**DEPARTMENT OF COMMUNITY SERVICES**

May 13, 2024

**Subject: Eagleview Subdivision Filing No. 1 Final Plat, 2<sup>nd</sup> Submittal – (SF-22-042)**

EAGLEVIEW  
A PORTION OF THE NORTHWEST QUARTER OF SECTION 26, TOWNSHIP 12 SOUTH,  
RANGE 65 WEST OF THE 6th P.M., EL PASO COUNTY, COLORADO

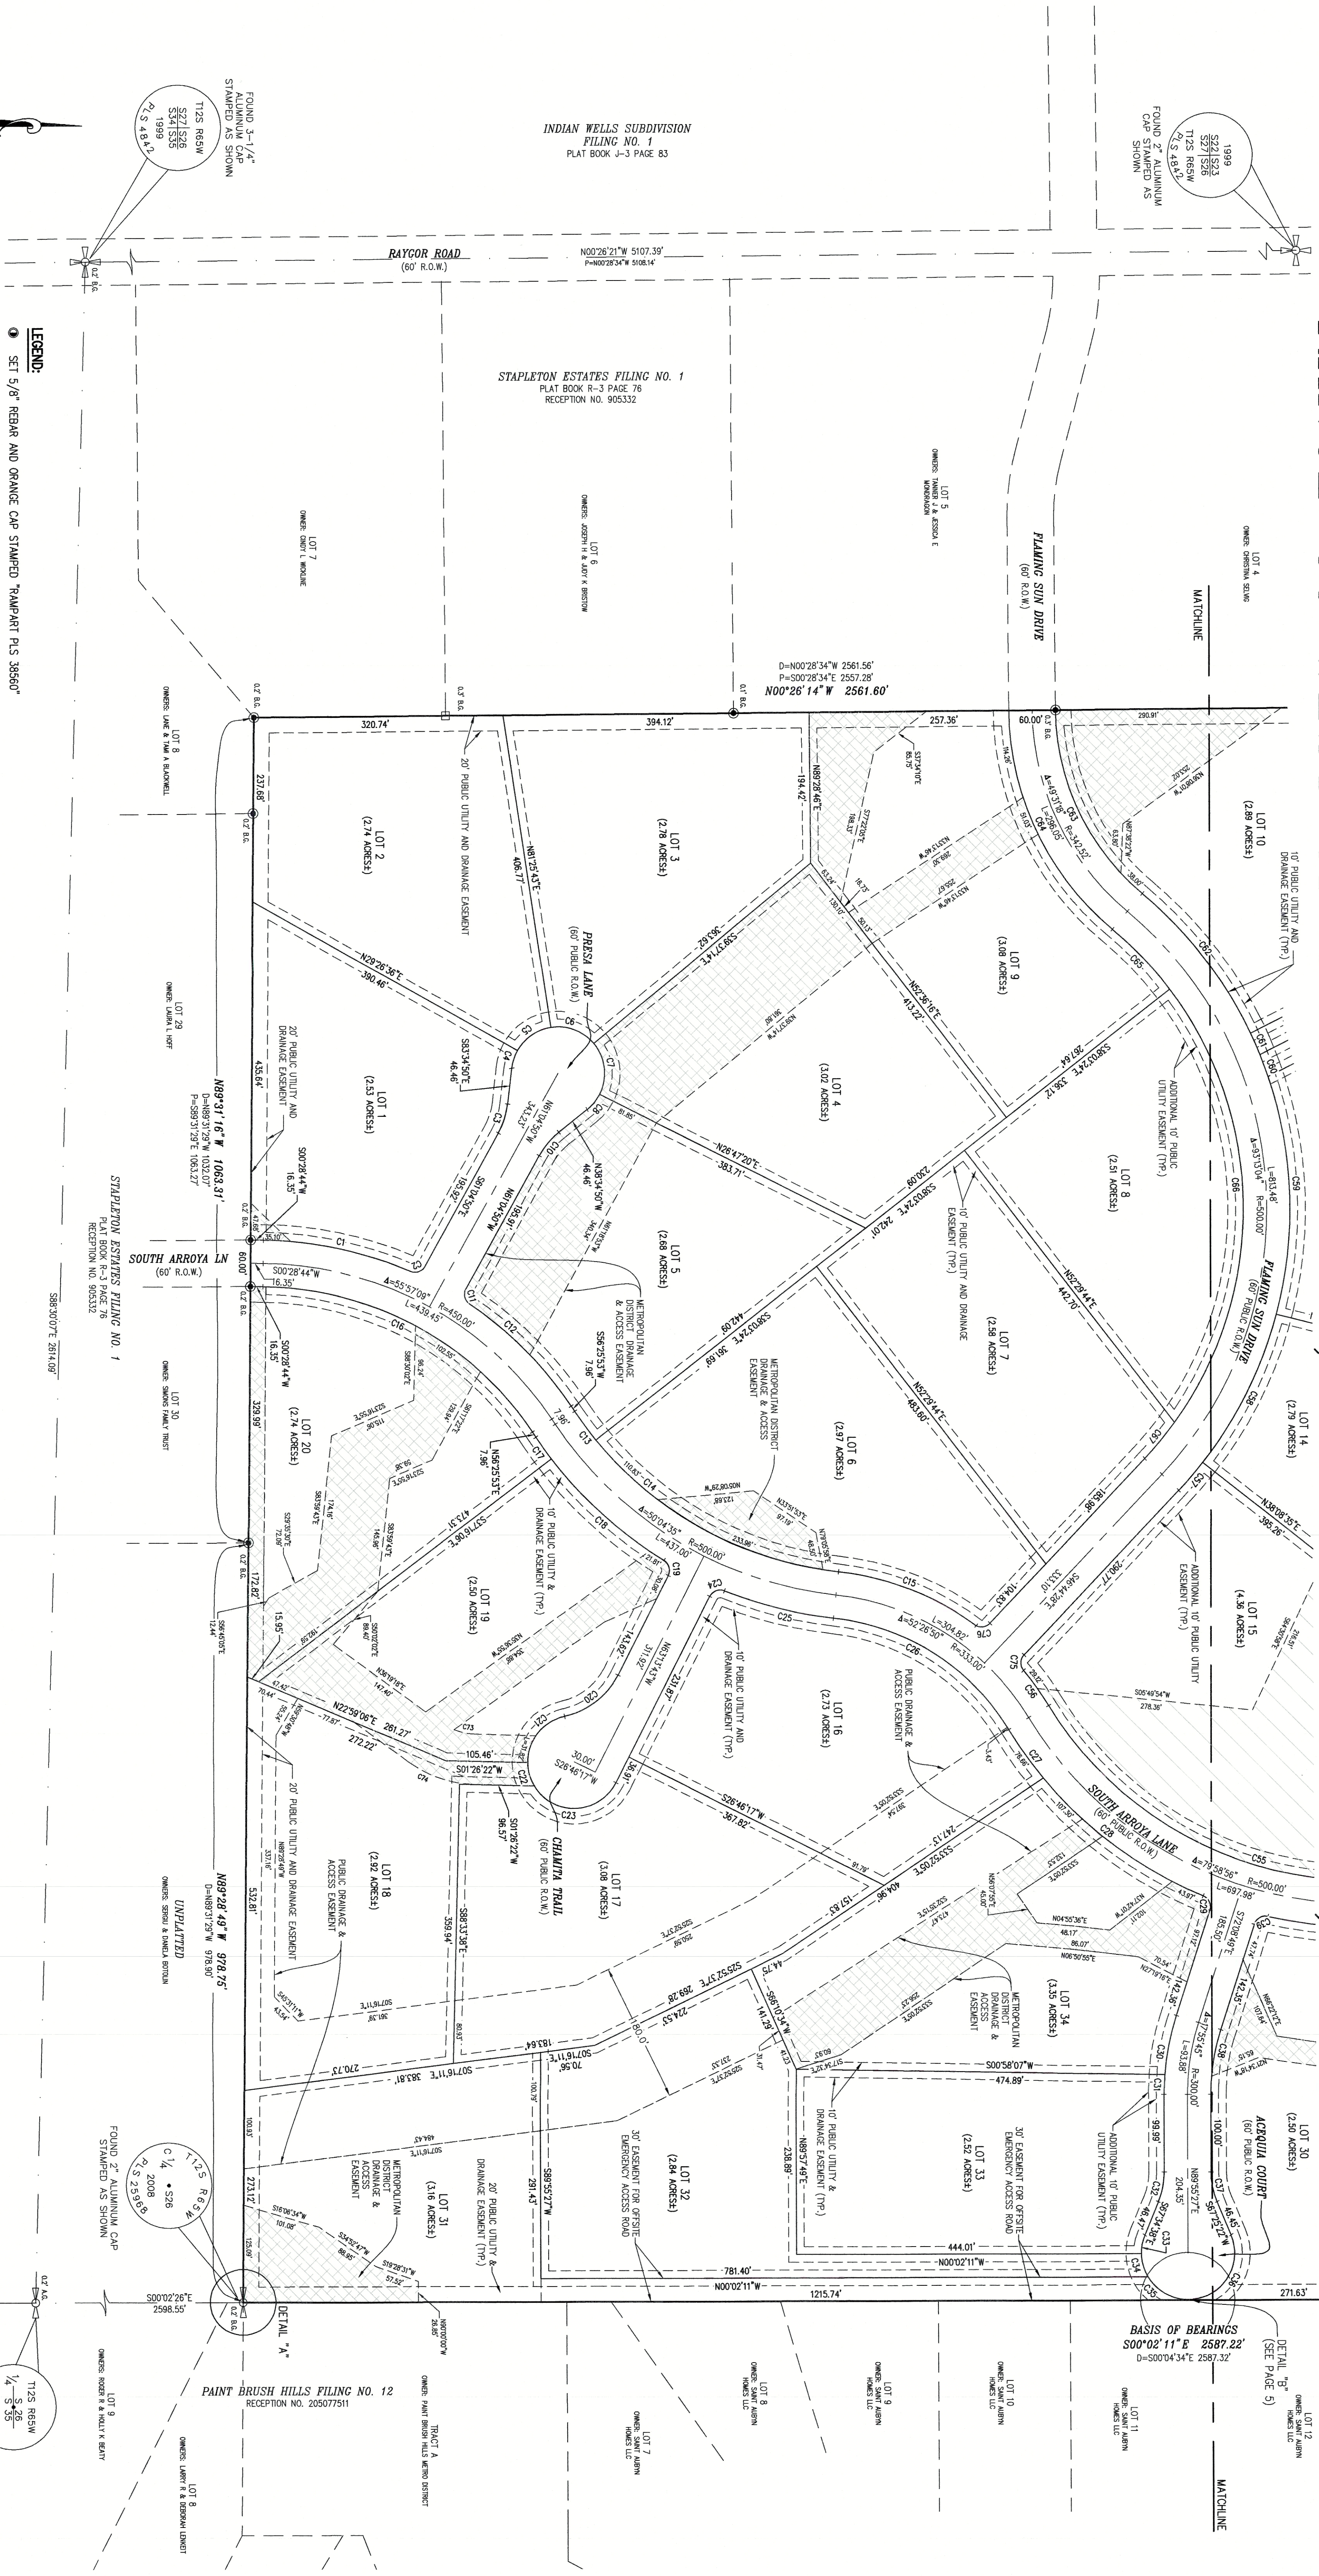
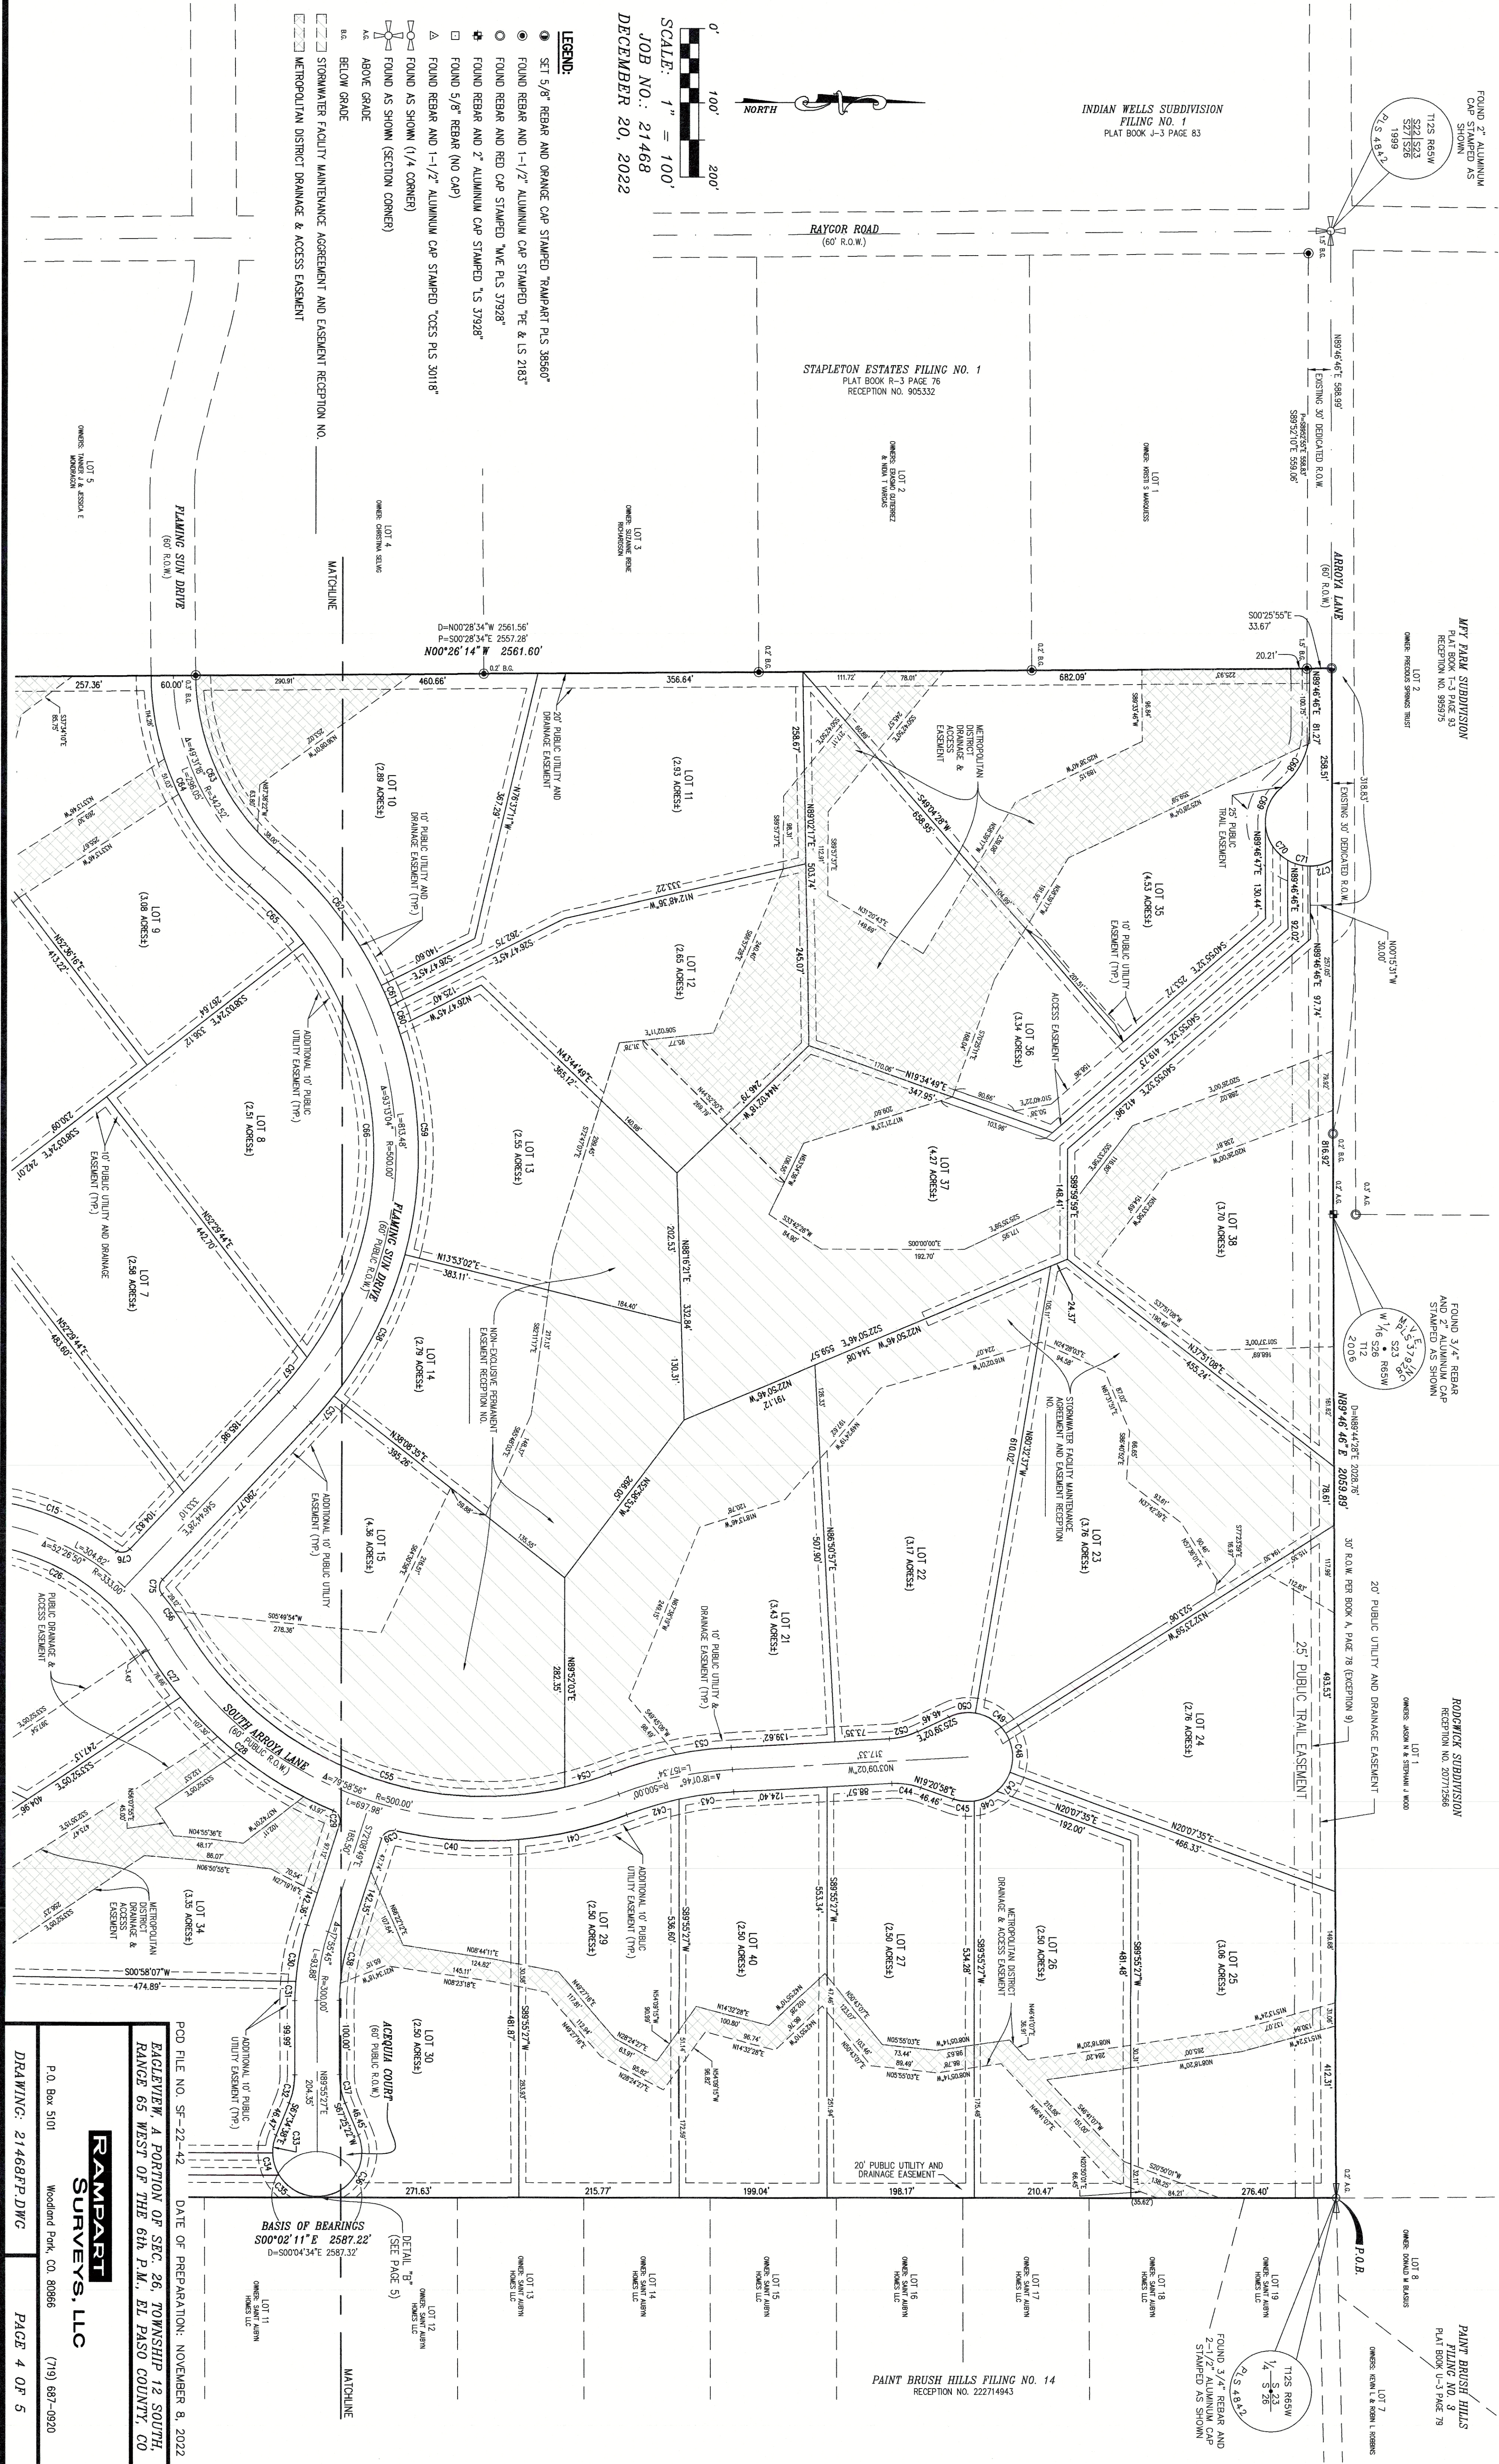
*Although shown properly on the approved Preliminary Plan, the applicant omitted the Arroyo Lane Primary Regional Trail easement from this Final Plat. This trail runs east-west across the northern portion of the project area and, as mentioned above, is present in the Trails Master Plan portion of the 2022 Parks Master Plan and is an important proposed regional trail*

Currently, this trail easement is only shown on Page 4 of the submitted Construction Documents. Therefore, staff recommends that a 25' trail easement be designated along the northern edge of Eagleview Estates, outside of the proposed Arroyo Lane right-of-way, which will allow for the construction, maintenance, and public access of the Arroyo Lane Primary Regional Trail. This easement shall be shown on the Final Plat and included in the Plat Easement Notes prior to the recording of Filing No. 1 Final Plat.

The Park Advisory Board recommends that the Planning Commission and the Board of County Commissioners include the following conditions when considering and/or approving the Eagleview Subdivision Filing No. 1 Final Plat: (1) designate and provide to El Paso County a 25-foot trail easement along the northern boundary of Eagleview Subdivision, outside of the Arroyo Lane right-of-way, that allows for the construction, maintenance, and public access of the Arroyo Lane Primary Regional Trail, and dedicate the aforementioned easement to El Paso County prior to the recording of this Final Plat; (2) fees in lieu of land dedication for regional park purposes in the total amount of \$17,480 will be required at the time of the recording of this Final Plat."
